Application Reference: 6/2024/1335/COND

Proposed development at: 31A Howardsgate Welwyn Garden City AL8 6AP

Proposal: Submission of details pursuant to condition number 2 (Replacement Window Details) and 5 (Details of Bin Storage) on planning permission 6/2022/2632/FULL

Authentic (2019) Cross Sections

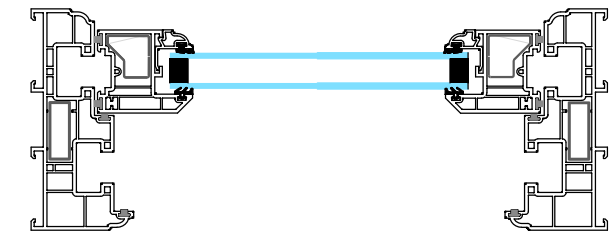
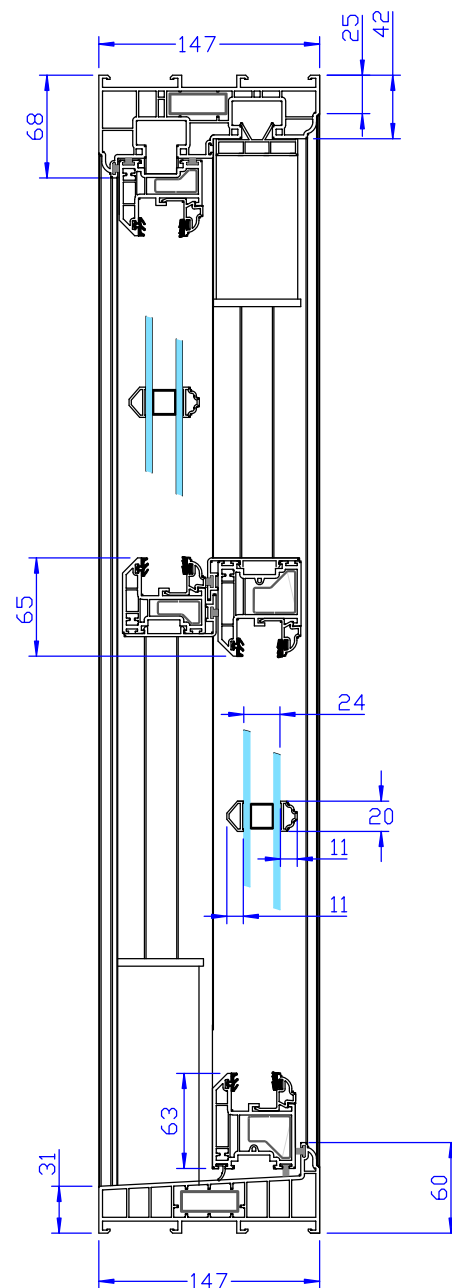
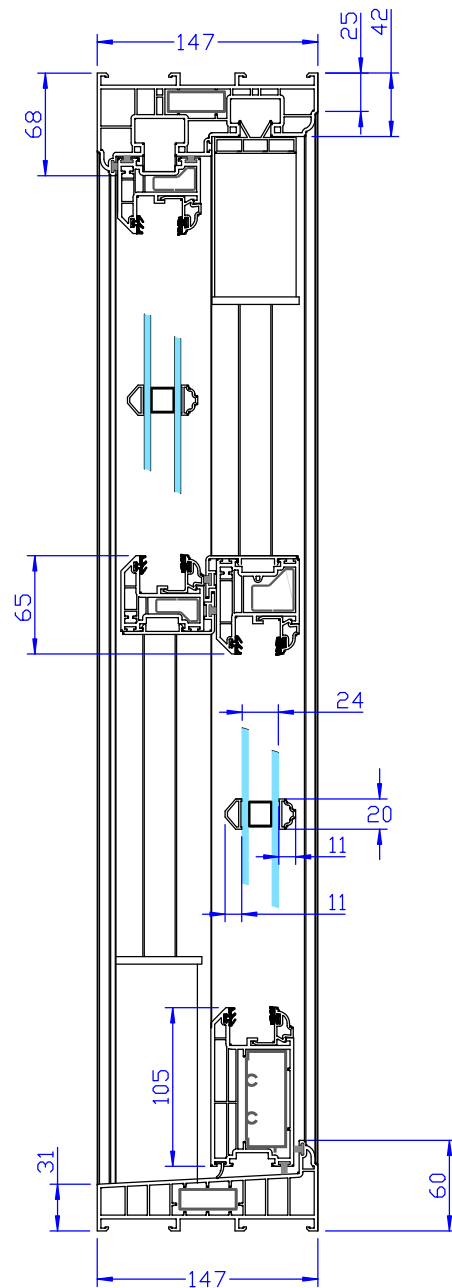
As part of the submission a window brochure by Masterframe and an “Authentic (2019) Cross Section” drawing have been received. The application has been assessed by the Council’s Conservation Advisor. They raise an objection to the proposed replacement windows.

This proposal seeks wholesale replacement of the timber sash windows to the front and side elevation. As noted above, the windows make a positive contribution to the architectural interest of the property. The loss of the windows would detract from the positive contribution the property makes to the significance of the Conservation Area. There is always a preference for repair over replacement. If the windows are beyond economical repair, then this should be demonstrated through a condition survey. No such survey has been received for review.

The proposed replacement windows are not acceptable from a conservation perspective. The proposed windows would be uPVC and have applied glazing bars. The replacement of traditionally made timber sash windows with modern windows of a non-traditional material and detailing would be inappropriate and unsympathetic, detracting from the architectural interest of Number 31A and the contribution it makes to the Conservation Area.

Regarding the requirement under condition 2, the replacement windows are not acceptable. Condition 2 is not agreed.
